From: David Fuller [REDACTED]
Subject: Seahaven - EP/75/19/PL - Revised proposed scheme
Date: 21 October 2019 at 12:58:41 BST
To: Juan Baeza <juan.baeza@arun.gov.uk>, Zac Denton <zac.denton@arun.gov.uk>
[REDACTED]

You kindly agreed to look at revised drawings informally before we look to substitute them with the current proposals. Therefore I attach revised drawings for informal discussion which address the concerns as follows:

Ground Floor Plan

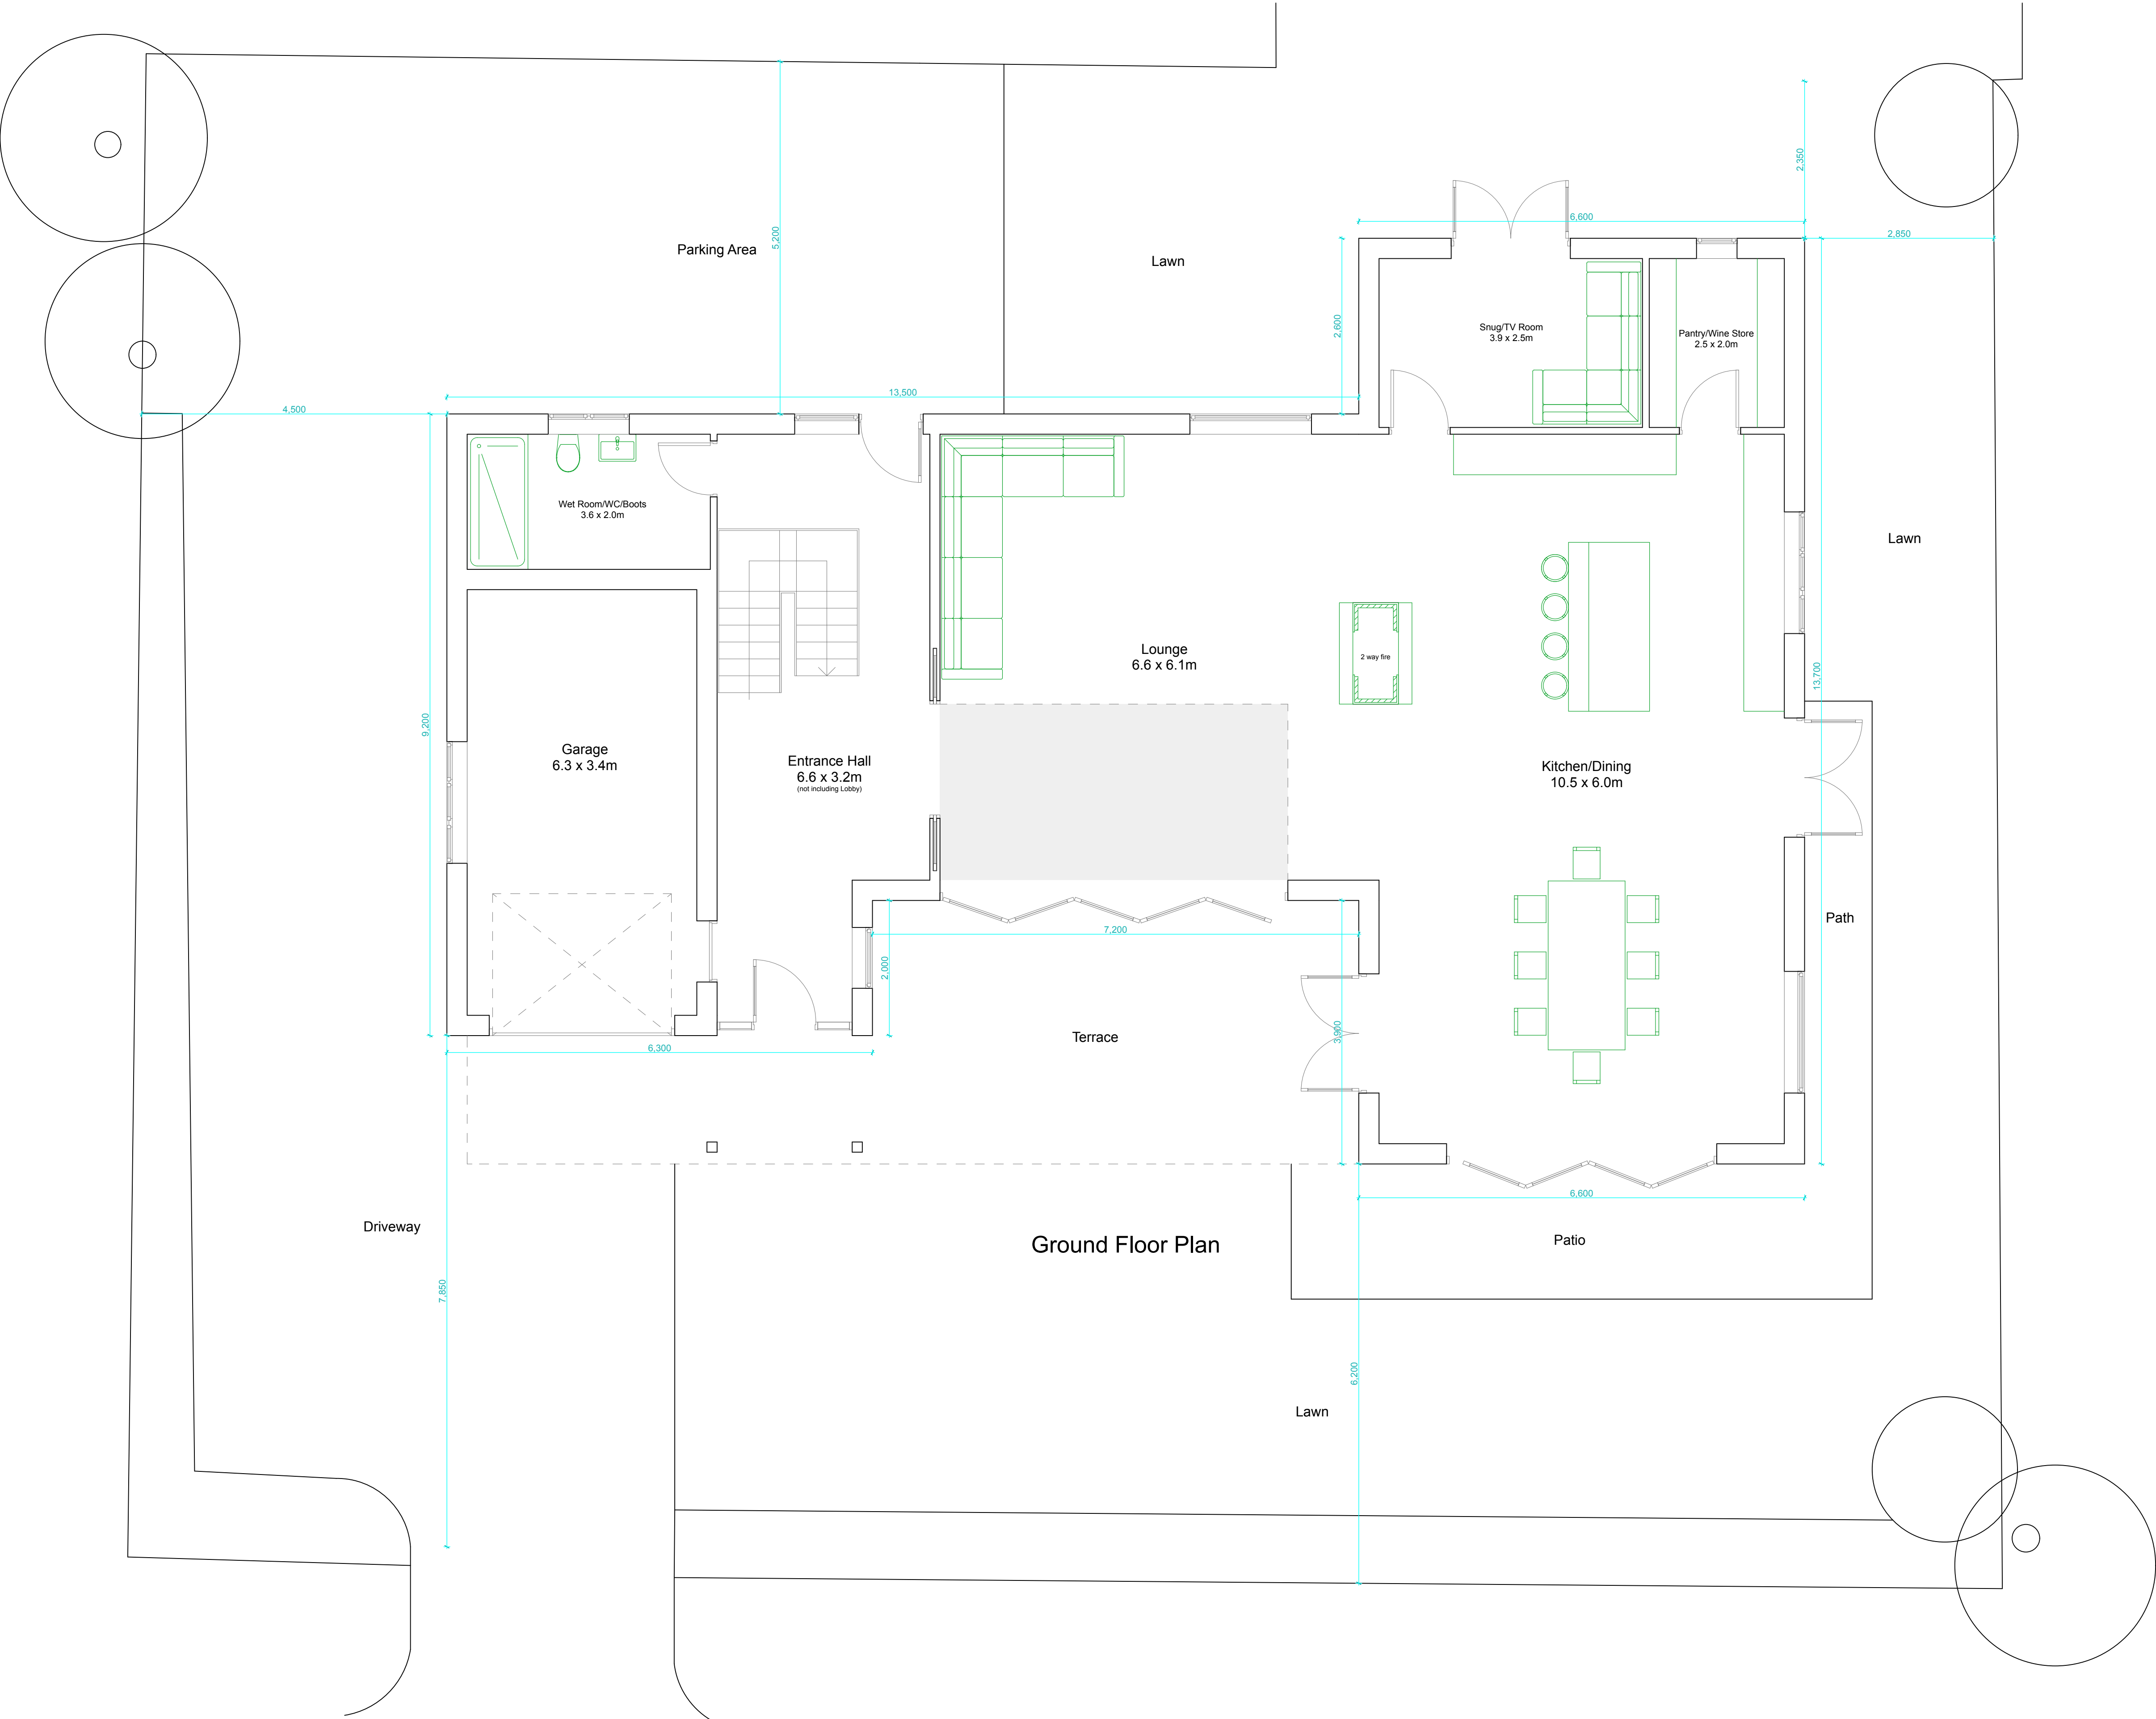
The additional ground floor area proposed by the current scheme is 12.6m² to the Garage and Entrance Hall to the Southwest of the building. There is 2.6m² proposed by moving the Southern wall of the Dining Area further to the South by 400mm, making a total increase in floor area of 15.2m² from the original consented scheme. The plot/building ratio statistics are as follows:

Additional land to Northeast (shown on location and block plan) = 88m²

First Floor Plan

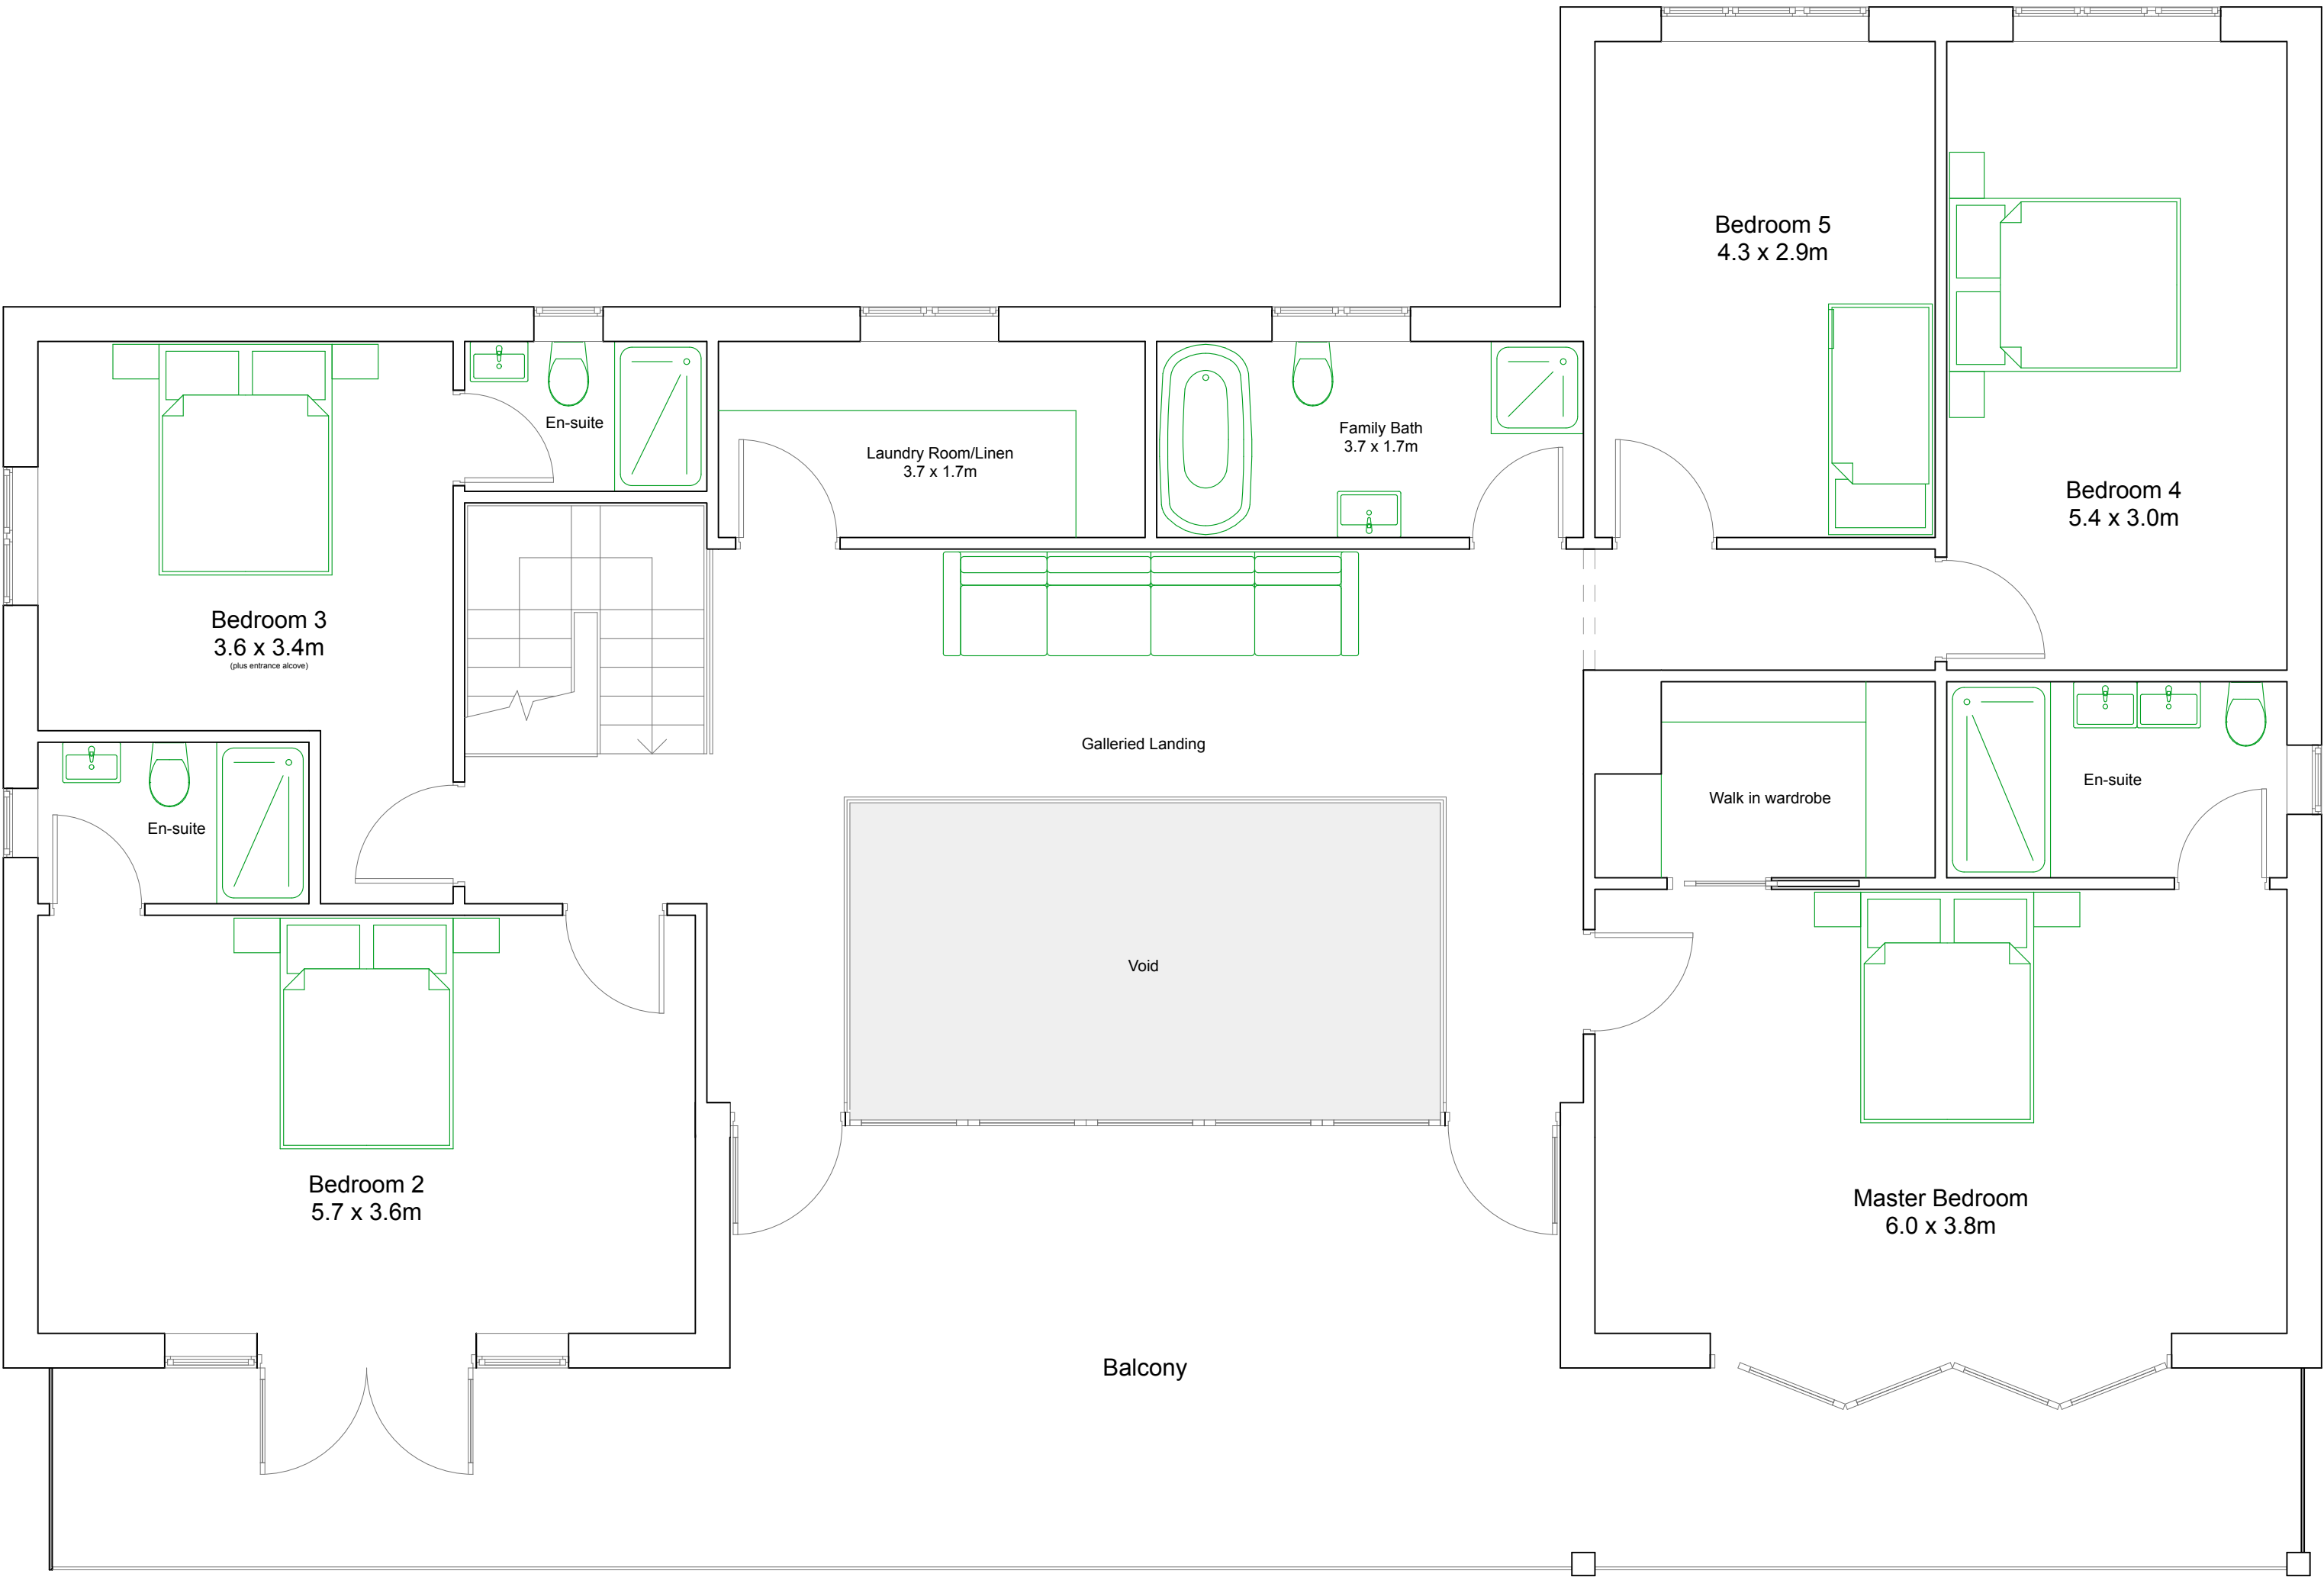
The window in Bedroom 3 window to the West Elevation has been reduced in size from a 3 light casement to a 2 light, to reduce the aperture width. We discussed this when we met, and I attach
